EP/5/15/HH

From: Anita Gardner
Sent: 10 February 2015 17:56
To: [REDACTED]
Subject: EP/5/15/HH - 11 Saxon Close, East Preston

Malcolm Westcott 07885977832	Project 11 Saxon Close East Preston West Sussex BN16 1DX	Drawing Title Location and Block Plan	Drawing No. 102	Revision	Scale As Indicated Date Dec 15	Rev Description By Date Client	Mr J. Gray
					Drawing Status		
					Drawn By Checked By

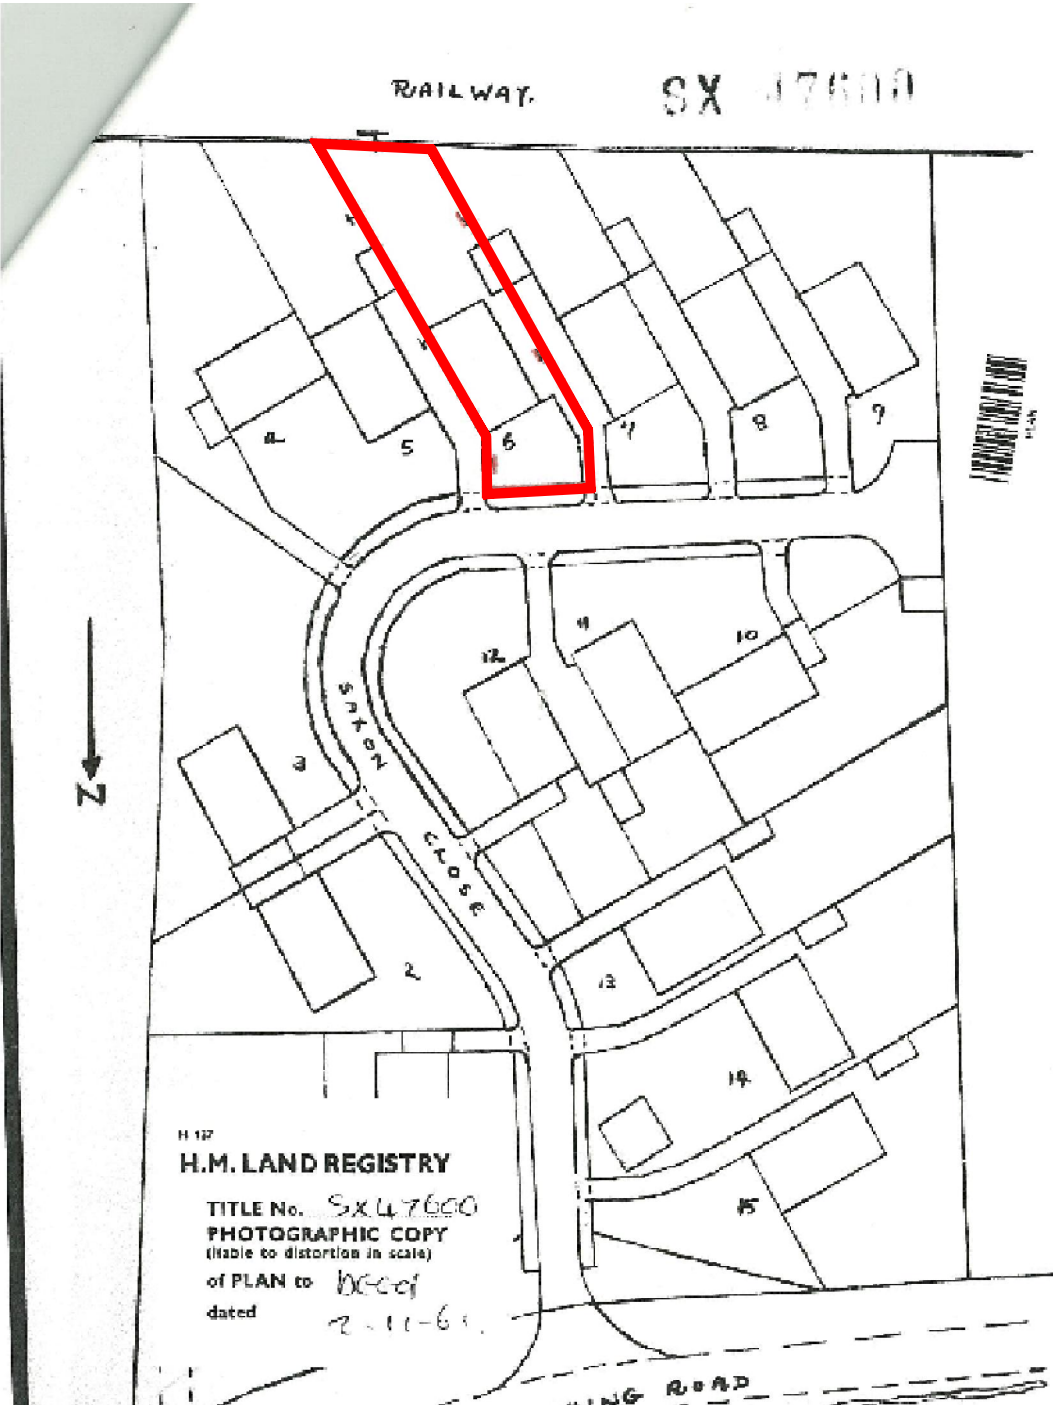
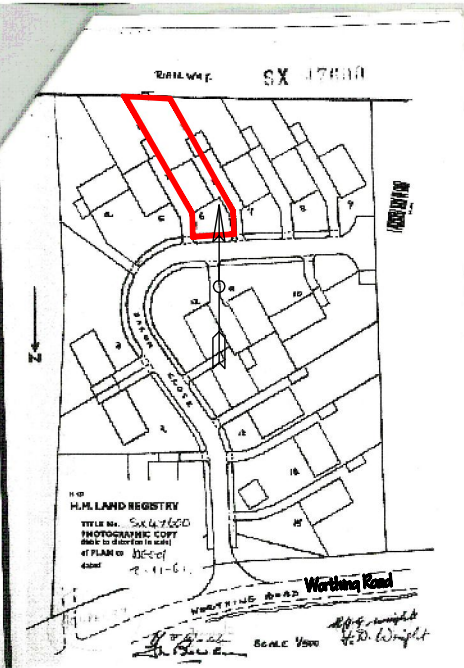
The above application was discussed at the Parish Council meeting last night and deferred for comment until the next meeting on 23-02-2015. The Clerk has written to me to request clarification of the plans submitted. The block plan should include the proposed extension hatched on it, with a dimensioned distance to the east side boundary indicated. It should also refer to house numbers not plot numbers. Can this be corrected? The side elevations do not contain a reference to the direction they represent and would be easier to understand if this annotation could be included. The existing and proposed floor plans are rotated 180 degrees which has caused some confusion. Can one of them be re-orientated?
